# ENG-SP20003-R5-PrelimPlan.pdf Markup Summary

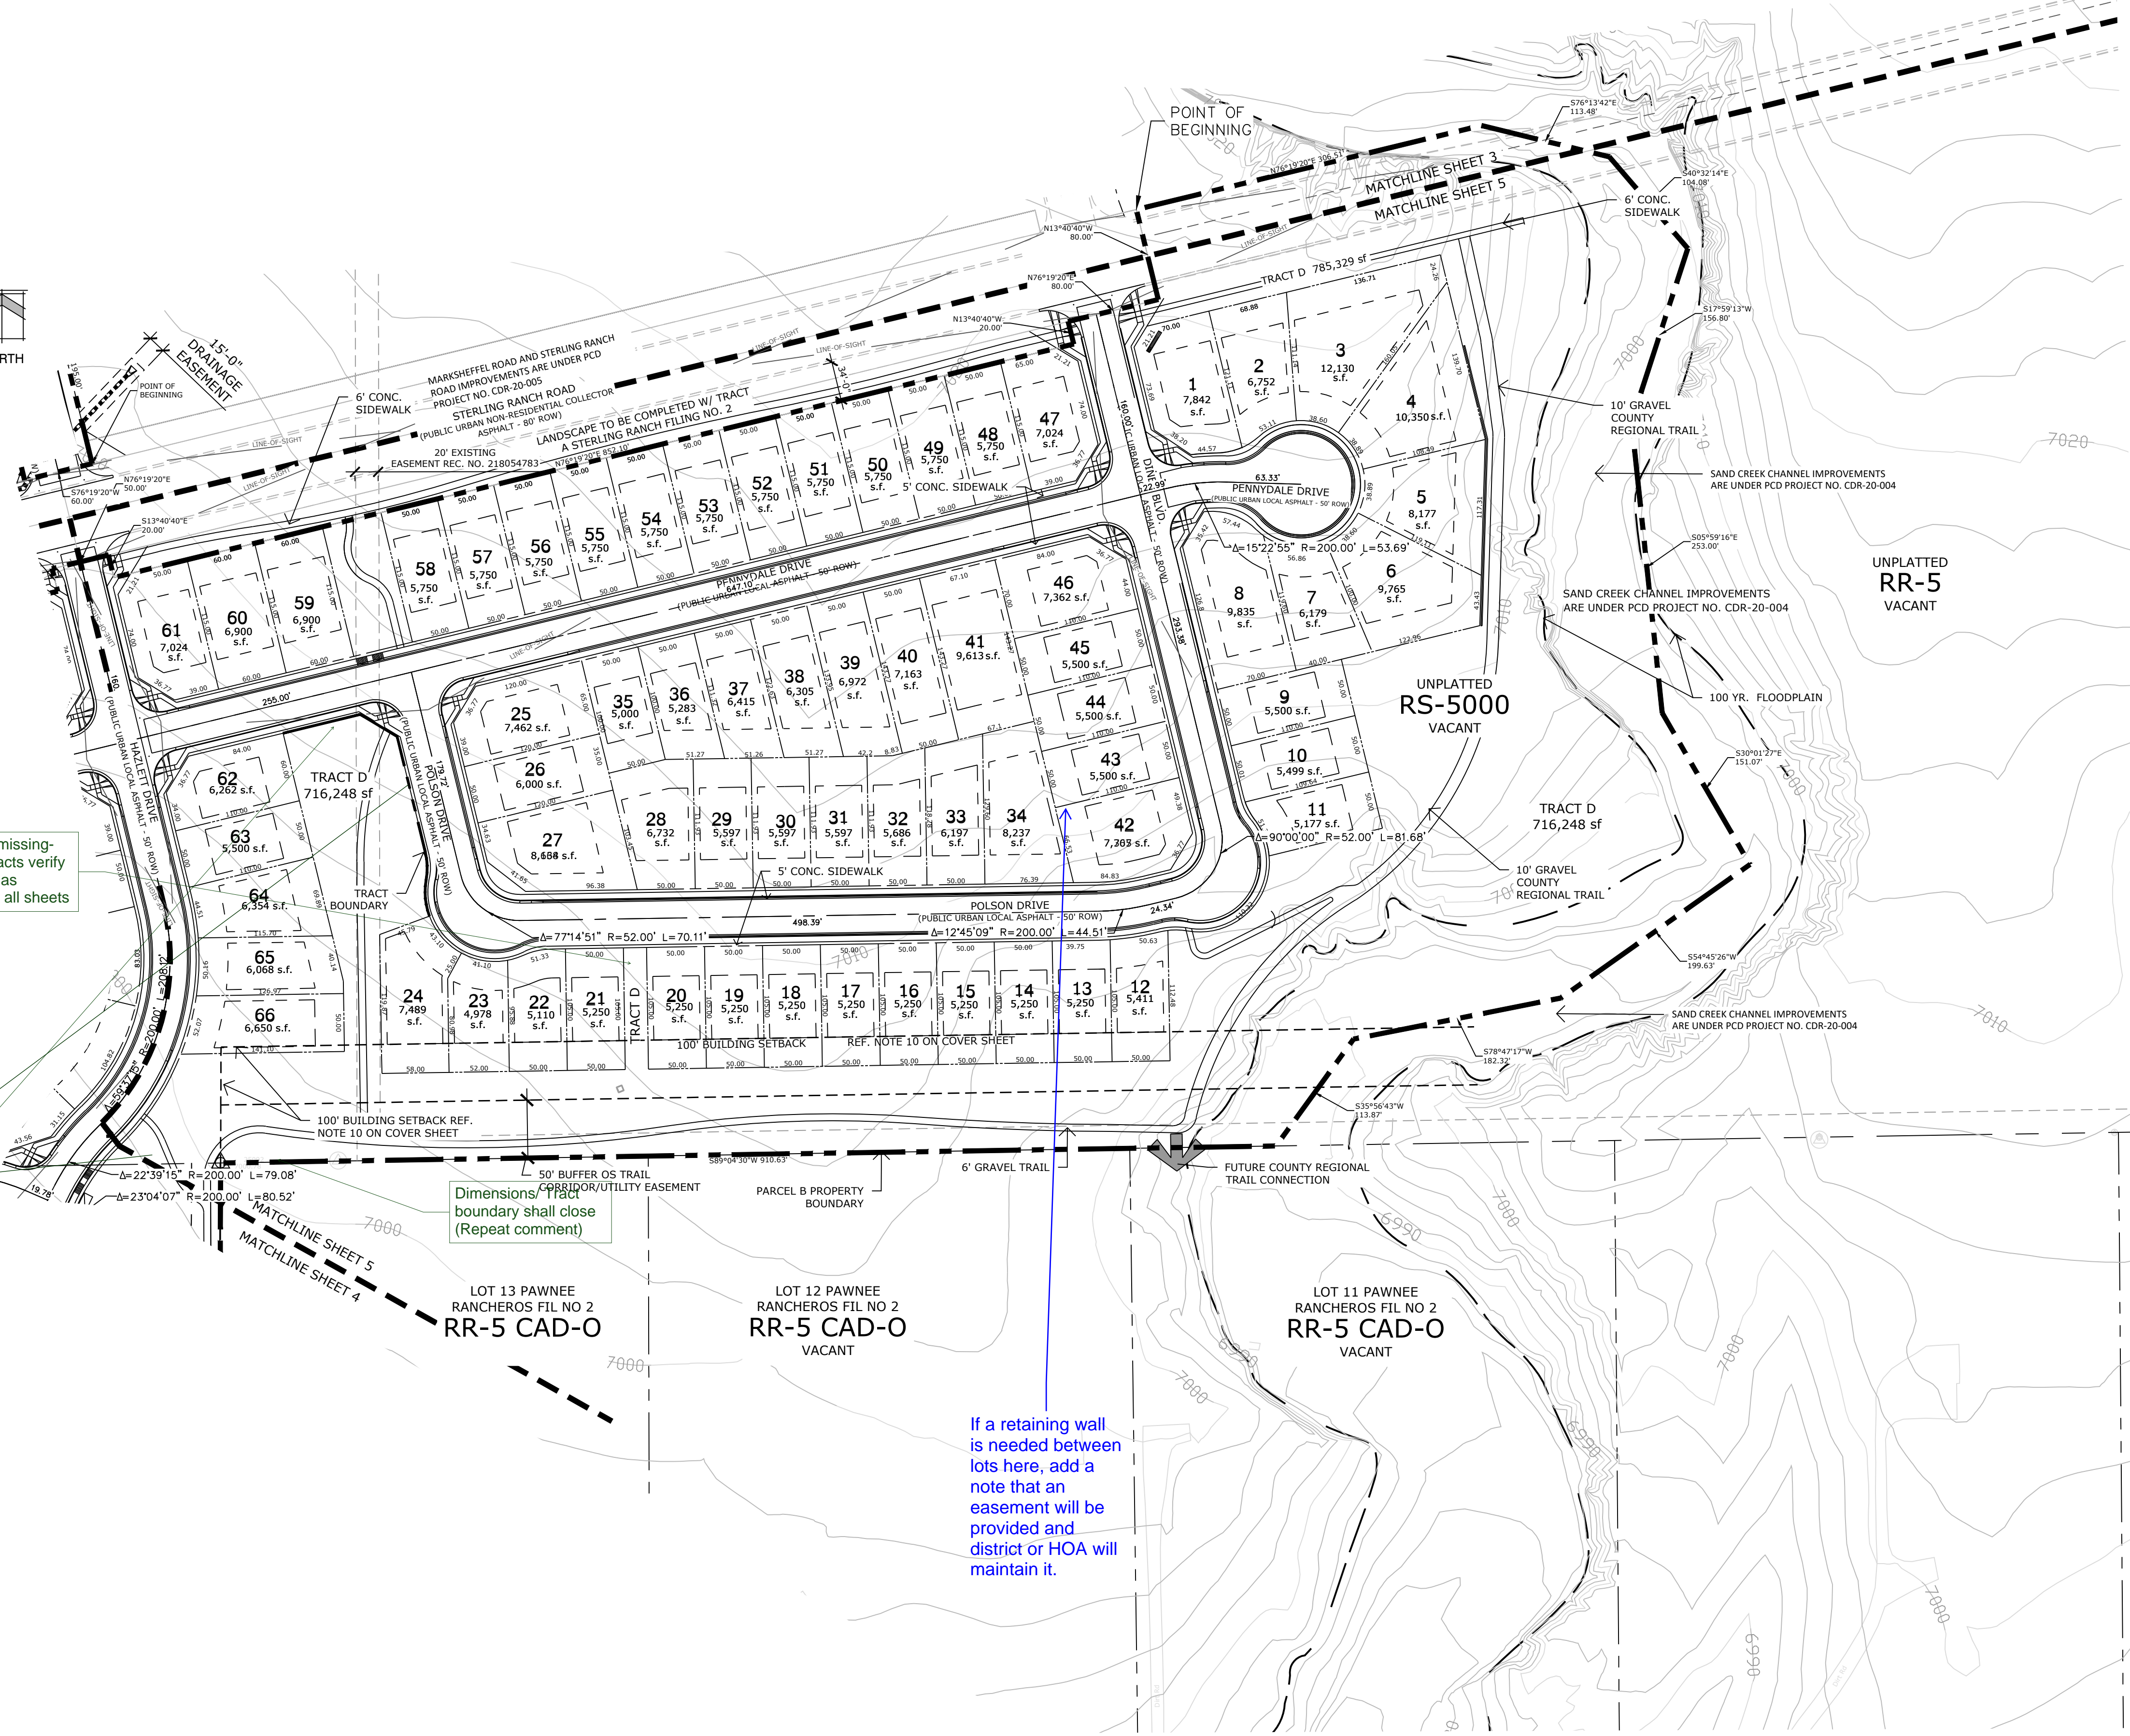
dimensions on all tracts just like you do for lots..REpeat comment

**RESPONSE:**  
Tract Dimensions  
& Take offs  
Provided

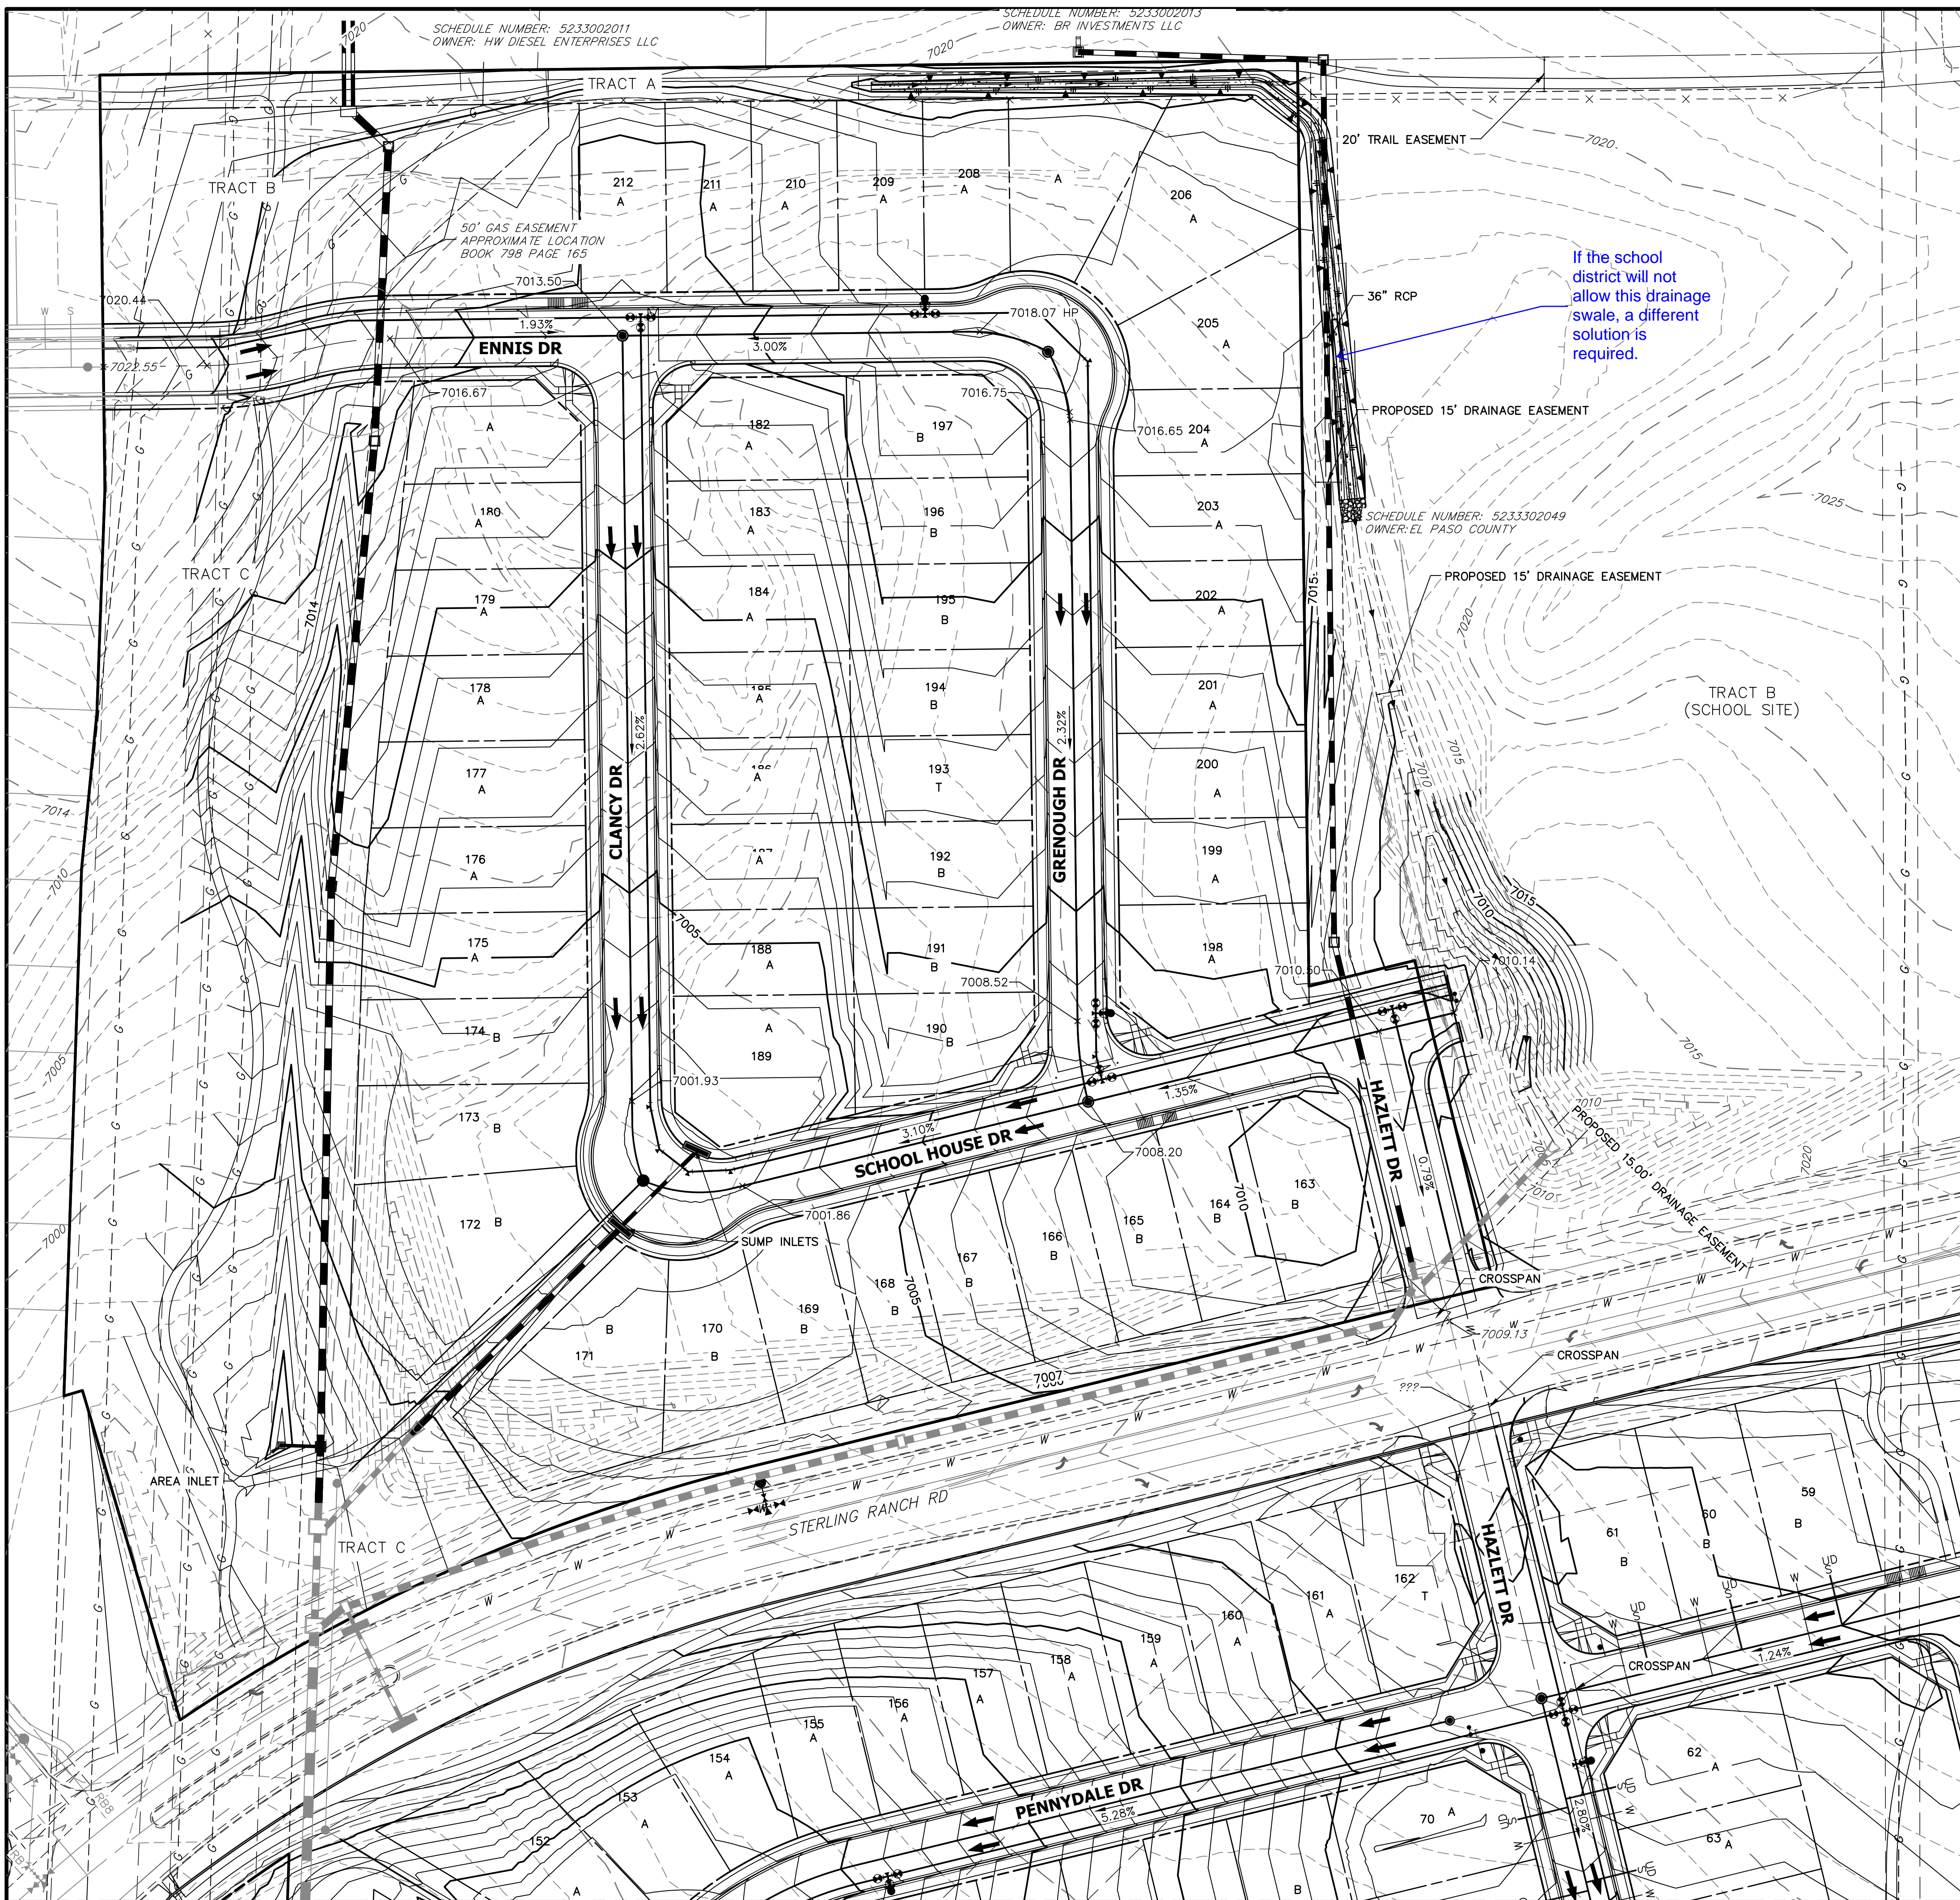
Dimensions/ Tract boundary shall close (Repeat comment)

dimension

dimension missing- check all tracts verify every line has dimensions all sheets

If a retaining wall is needed between lots here, add a note that an easement will be provided and district or HOA will maintain it.

**RESPONSE:**  
Tract Dimensions  
& Take offs  
Provided

**RESPONSE:**  
Tract Dimensions  
& Take offs  
Provided

**RESPONSE:**  
Tract Dimensions  
& Take offs  
Provided

**RESPONSE:** the lot grading has been revised to remove the retaining wall.

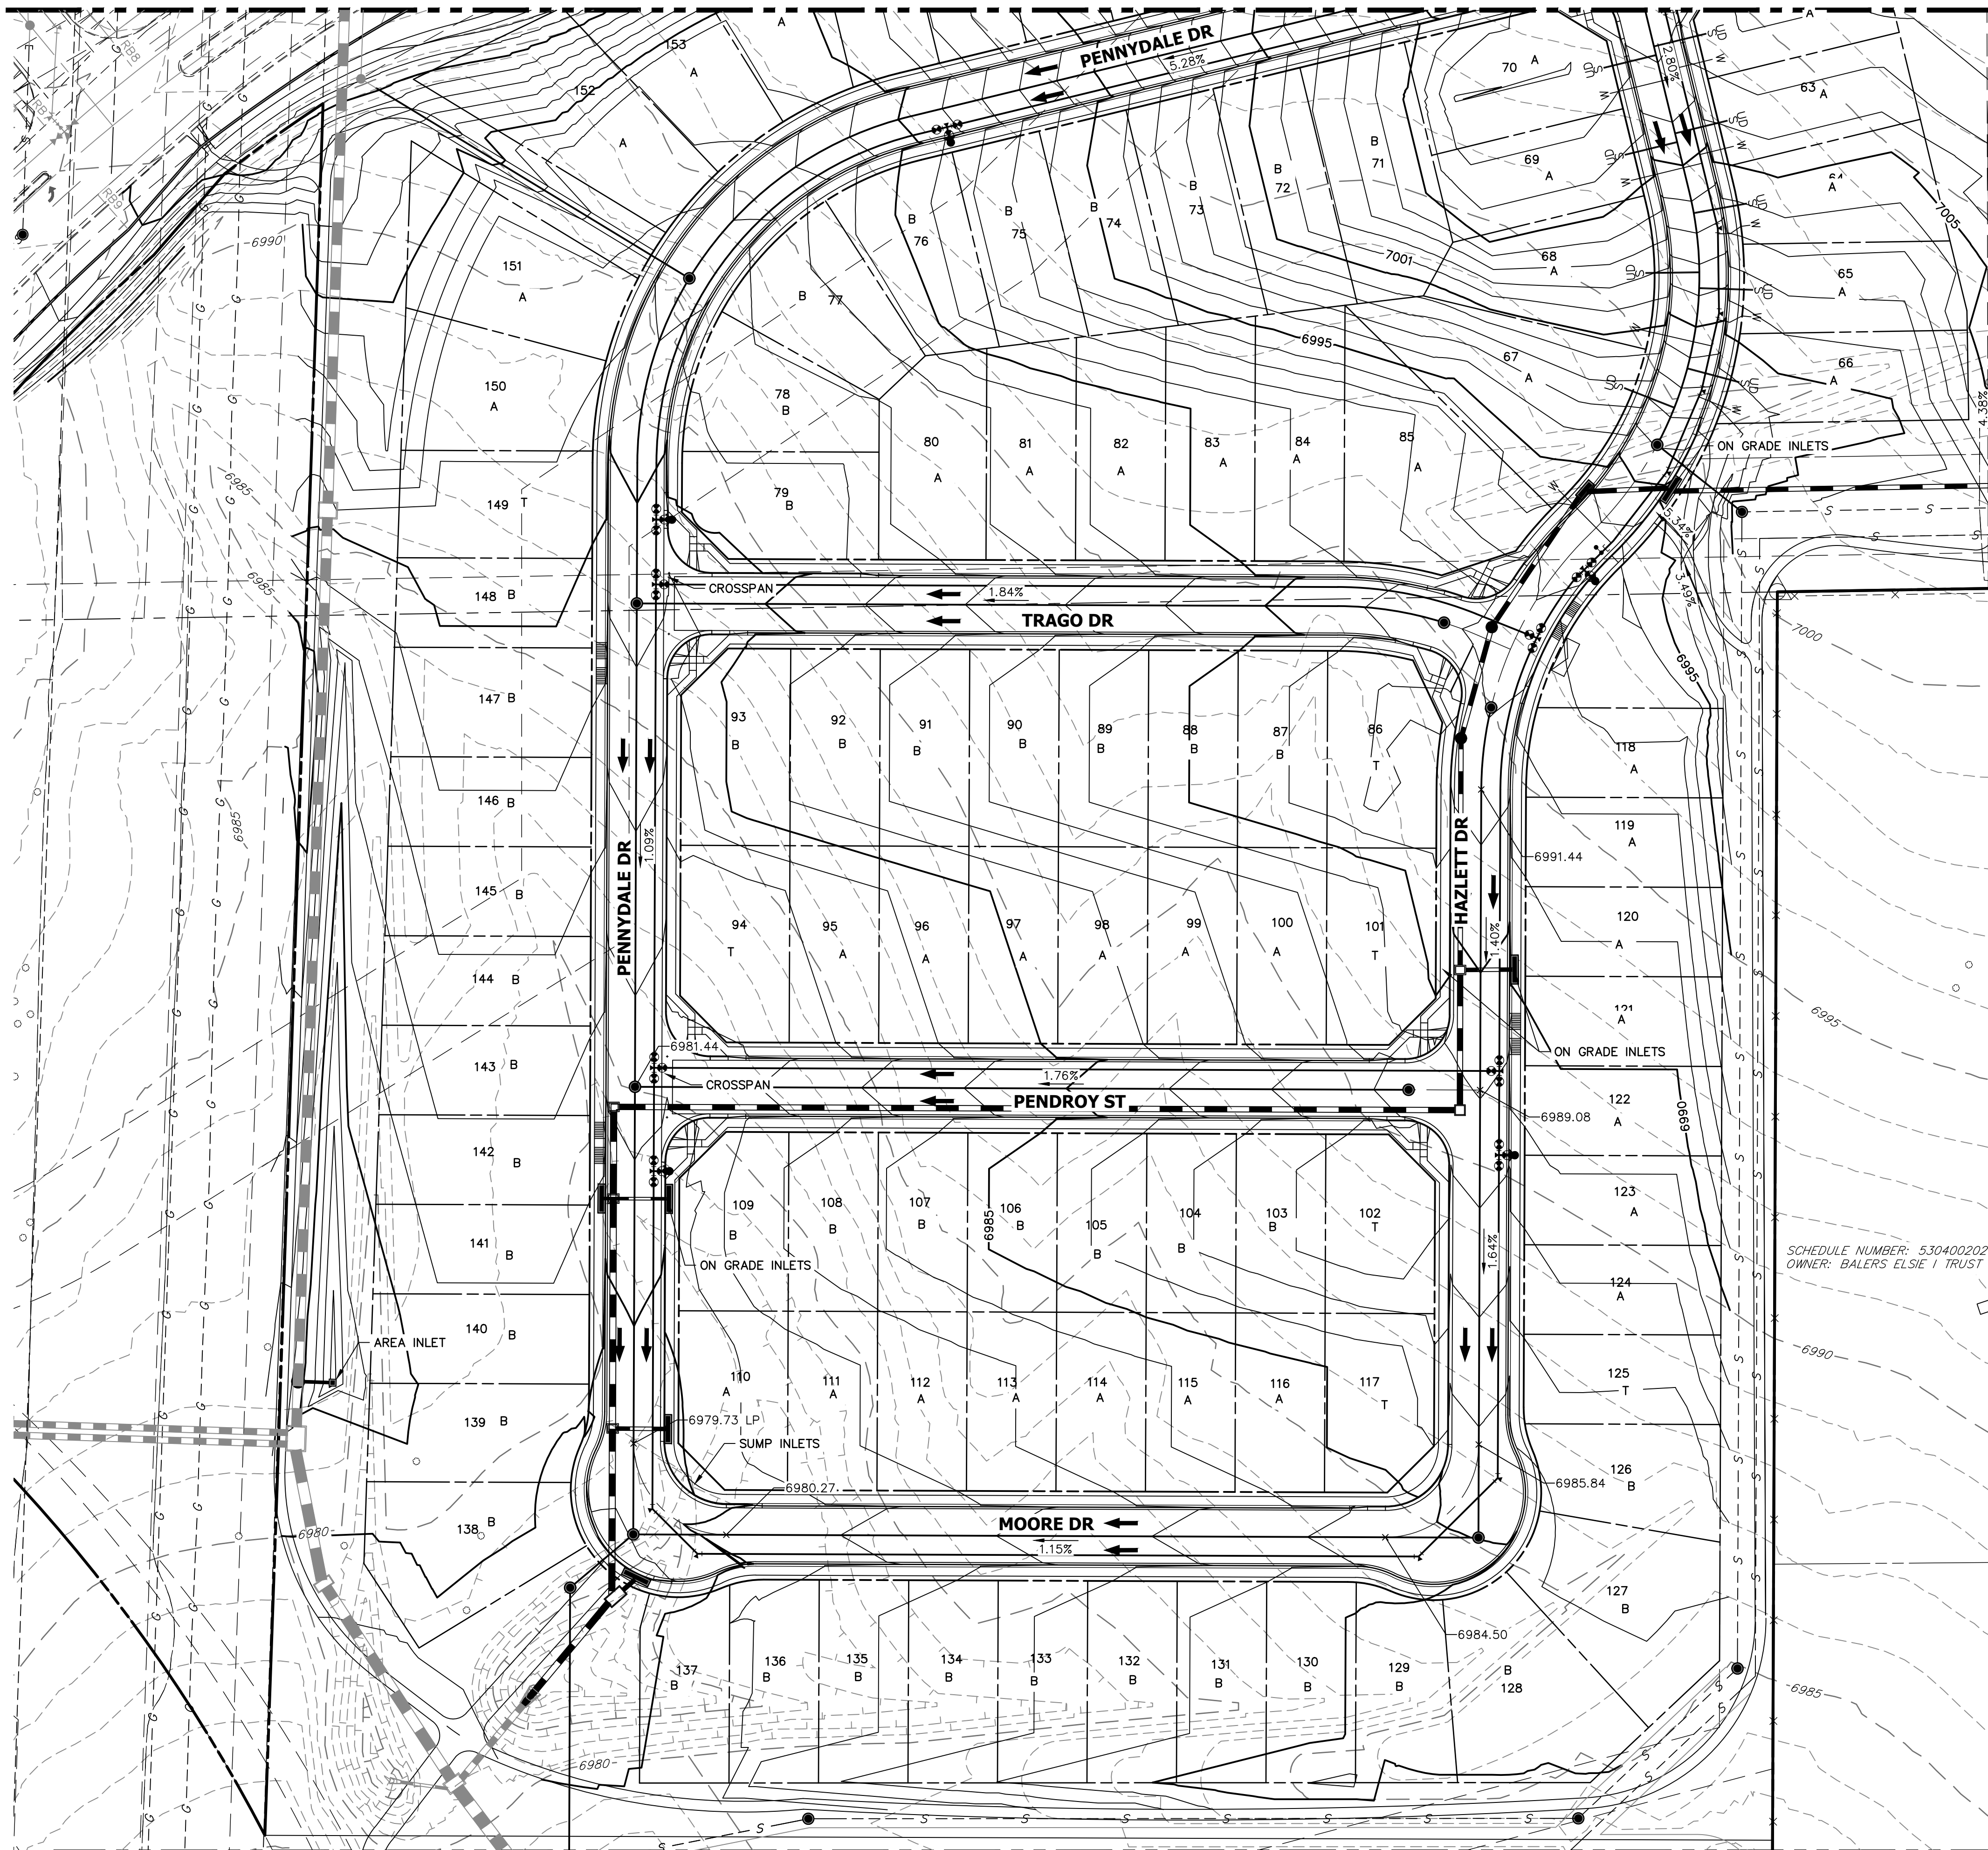
If the school district will not allow this drainage swale, a different solution is required.

**RESPONSE:** grading and drainage revised to eliminate grading and drainage on school site
